Our ref: DOC20/210768-9

Your ref: SSD-10378

Mixed-use Development, 42 Honeysuckle Drive, Newcastle (SSD-10378) – Review of Environmental Impact Statement

BCD has reviewed the *'Environmental Impact Statement: Construction of a Mixed Use Development, Including Commercial / Retail Uses and Hotel Accommodation – 42 Honeysuckle Drive, Newcastle NSW 2300'* (prepared by KDC Pty Ltd and dated February 2020), including relevant appendices, annexures and attachments in relation to impacts on biodiversity, Aboriginal Cultural Heritage and flooding.

Figure 5.4 Excerpt of Current East-West Section plan for the development.
Bates Smart Section East-West Plan No. A11.001 (September 2017).

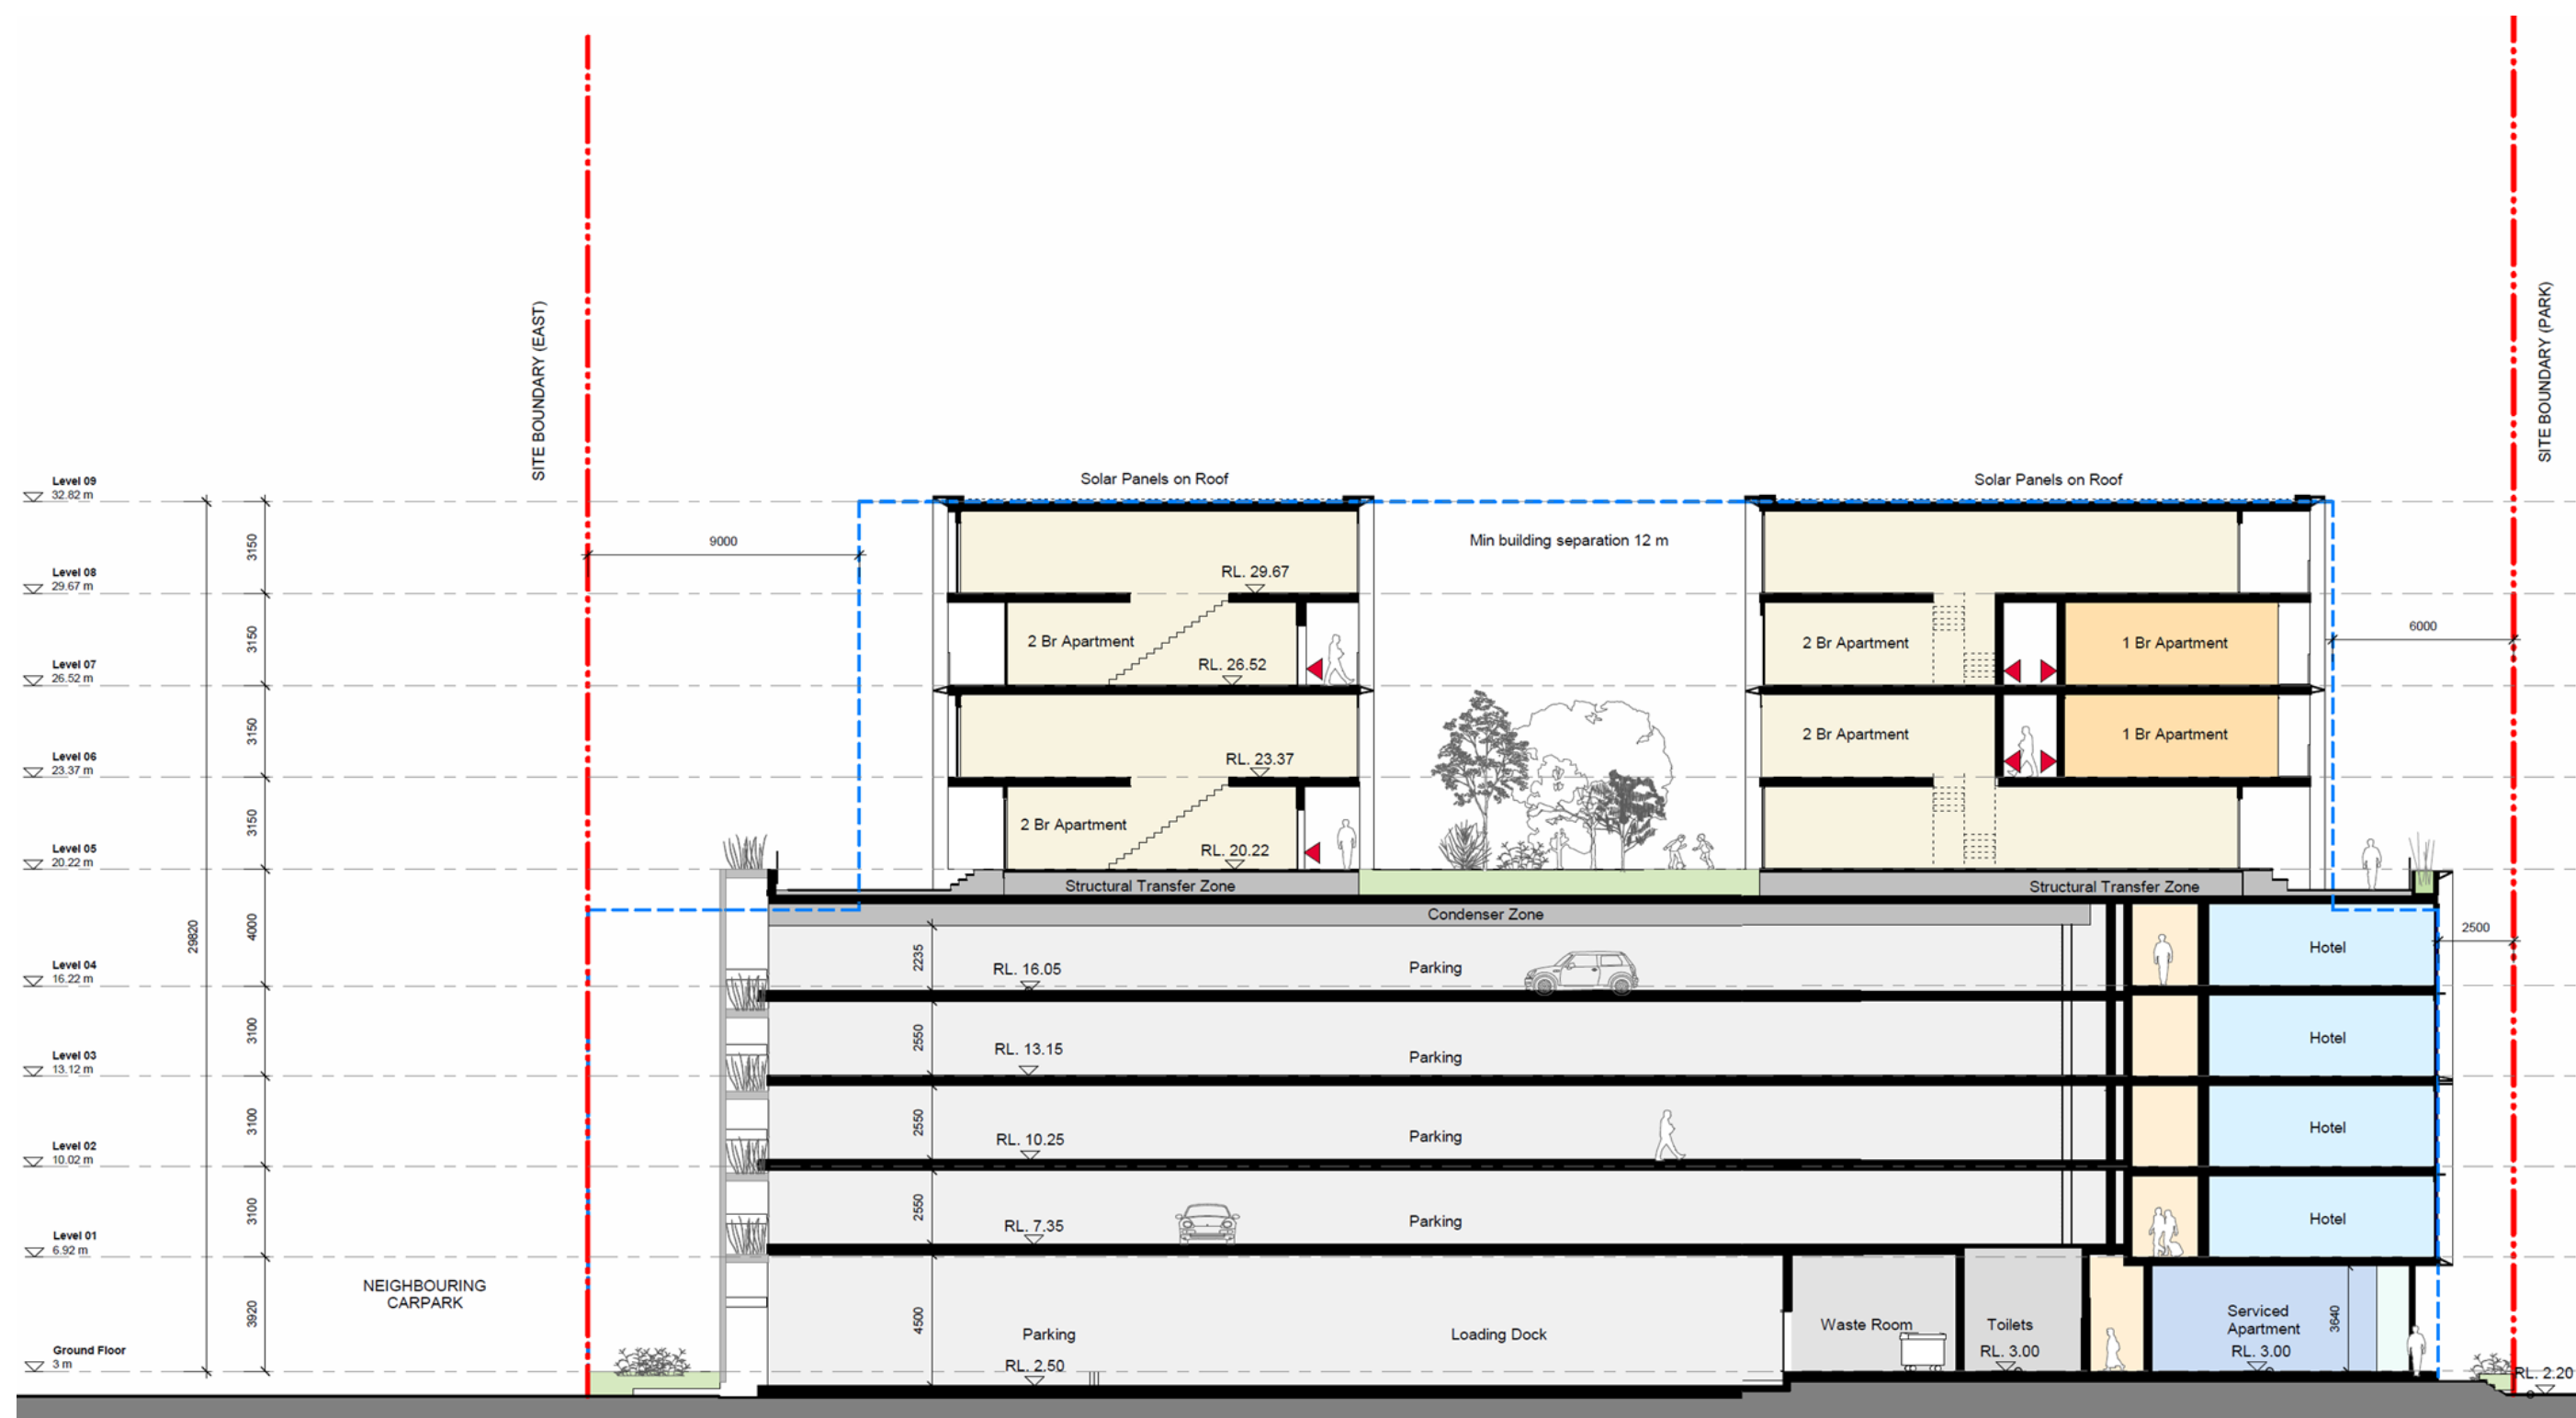
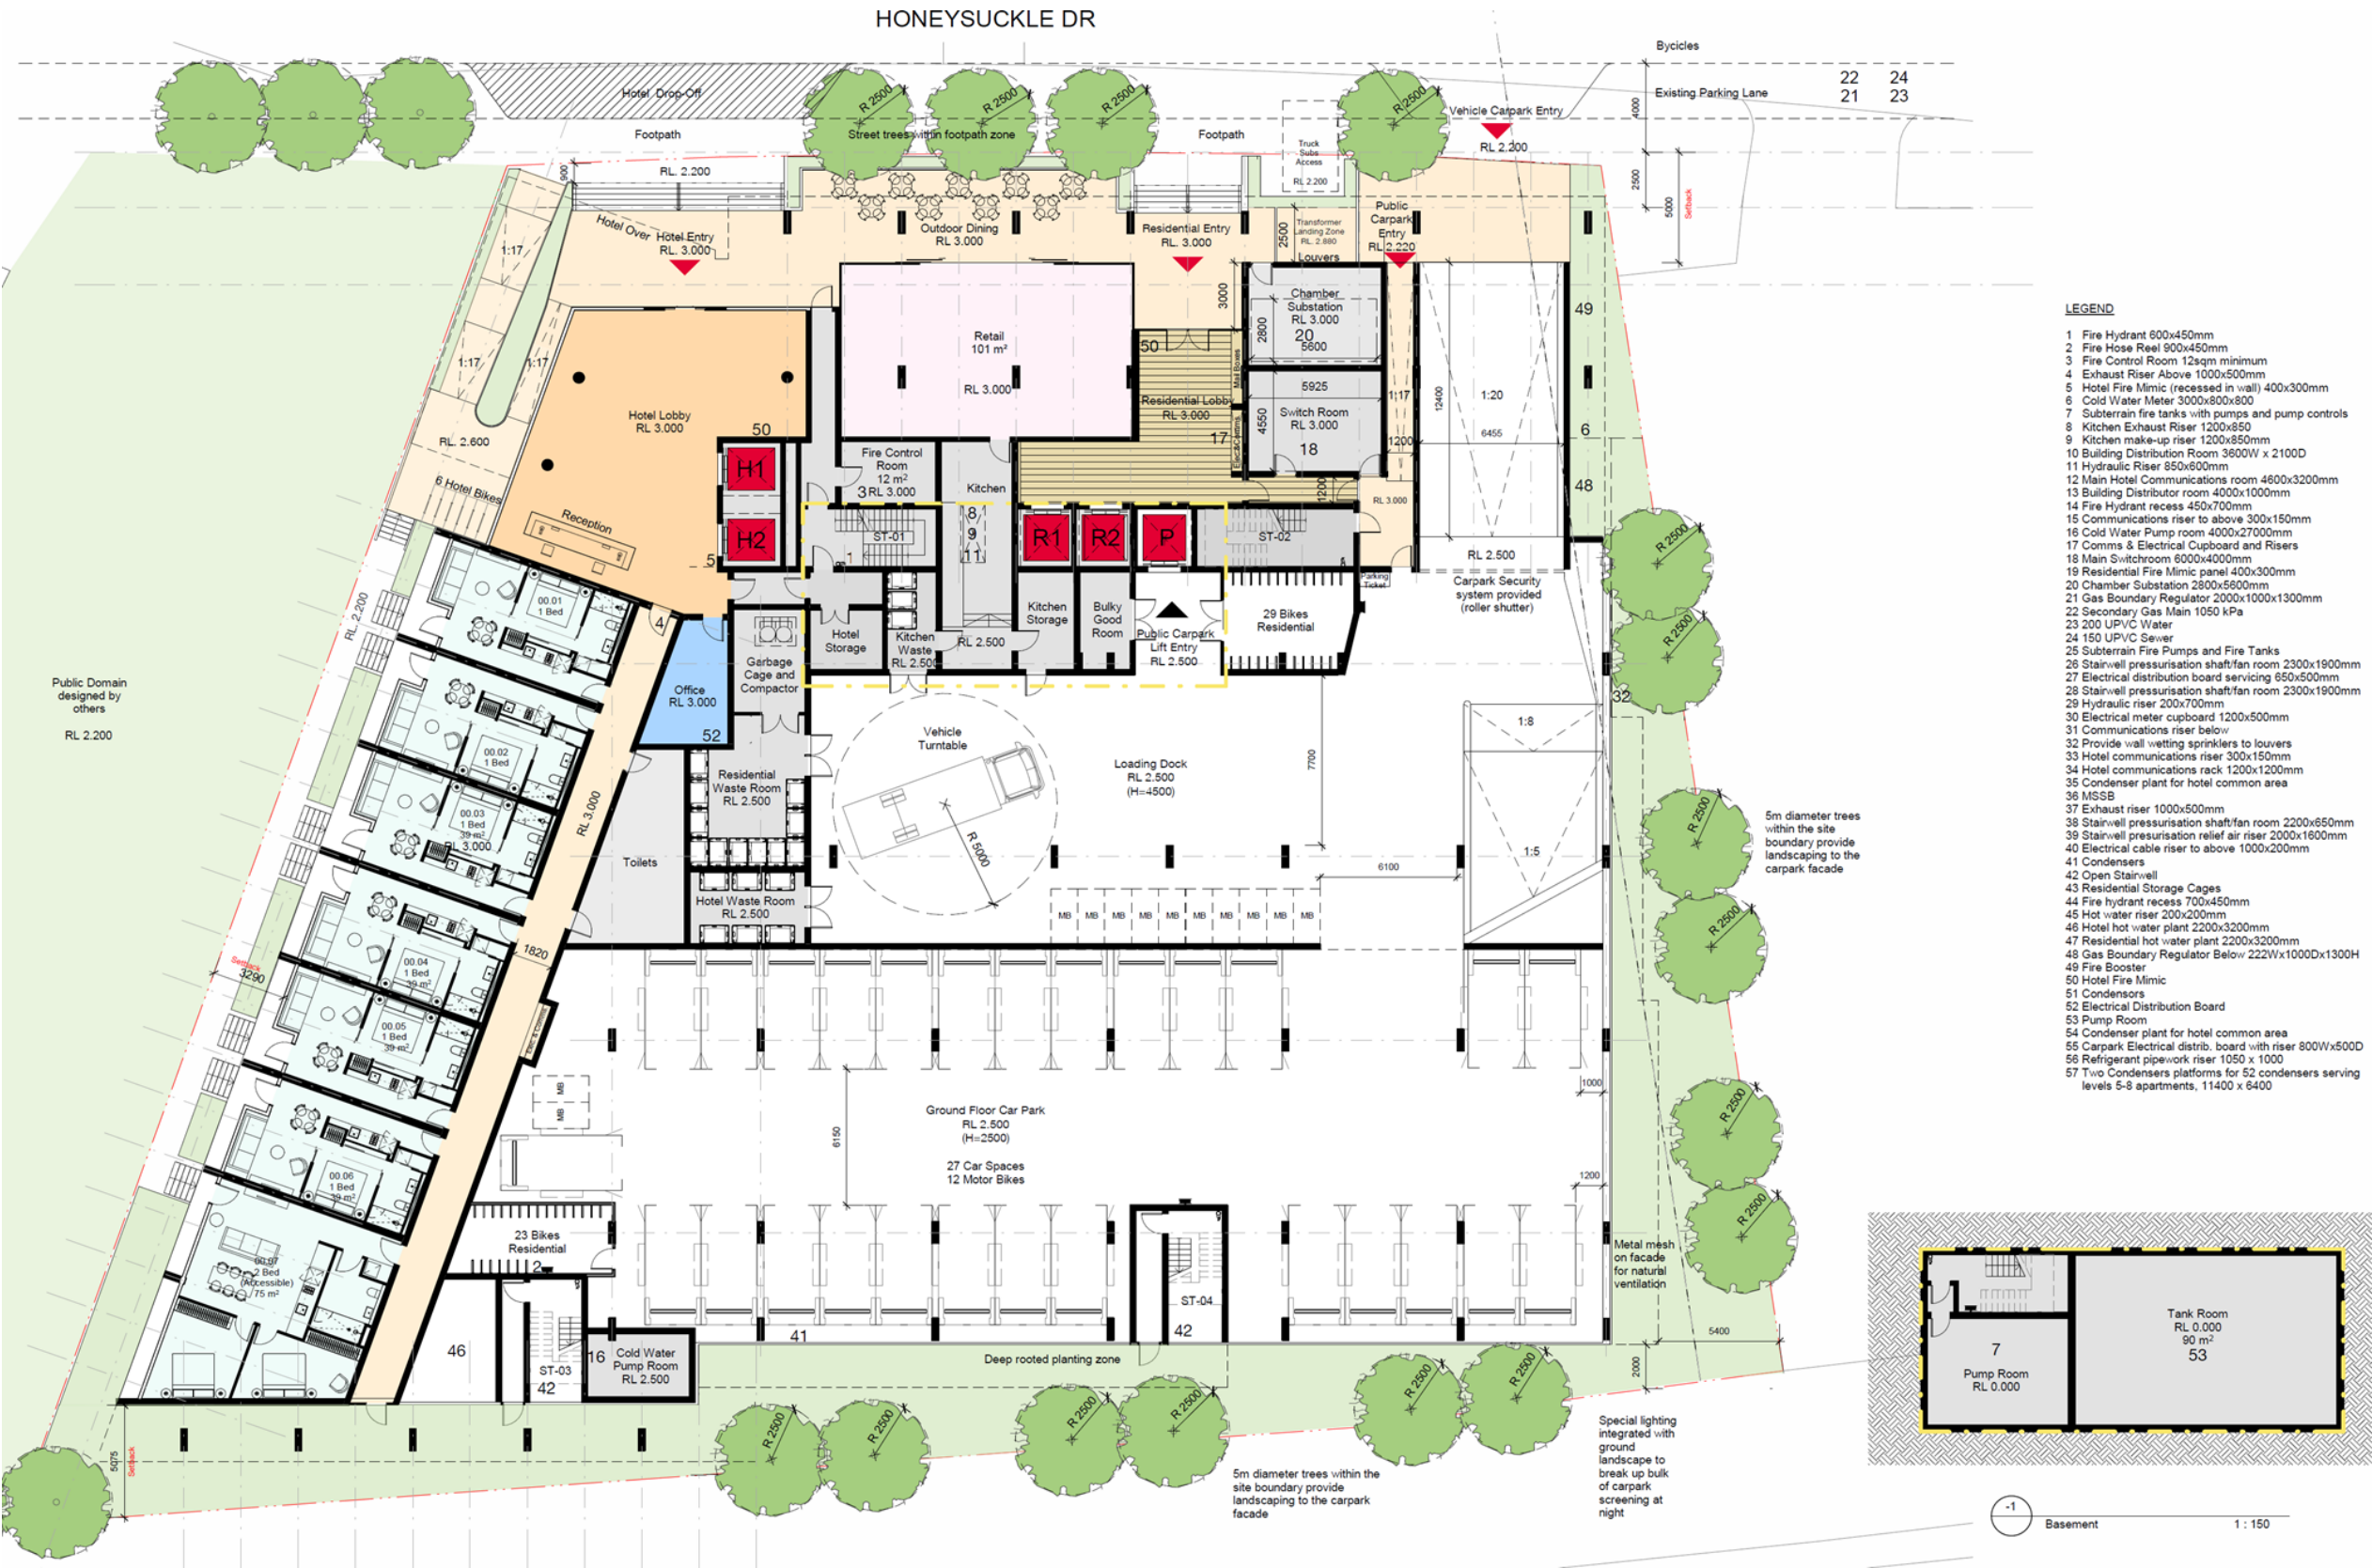
The EIS for the current SSD application (SSD 10378) refers to additional earthworks being required which include, but are not limited to, six new piles, capping and step-downs. Details of the location and extent of these earthworks have not been provided.

It is not clear whether the extent and depth of the development footprint for the current SSD application (SSD 10378) exceeds that of the previously approved SSD area (SSD 8840).

BCD recommends that the extent and depth of the development footprint for the SSD 10378 application area be provided and includes a comparison of the development footprint of the current and previous projects.
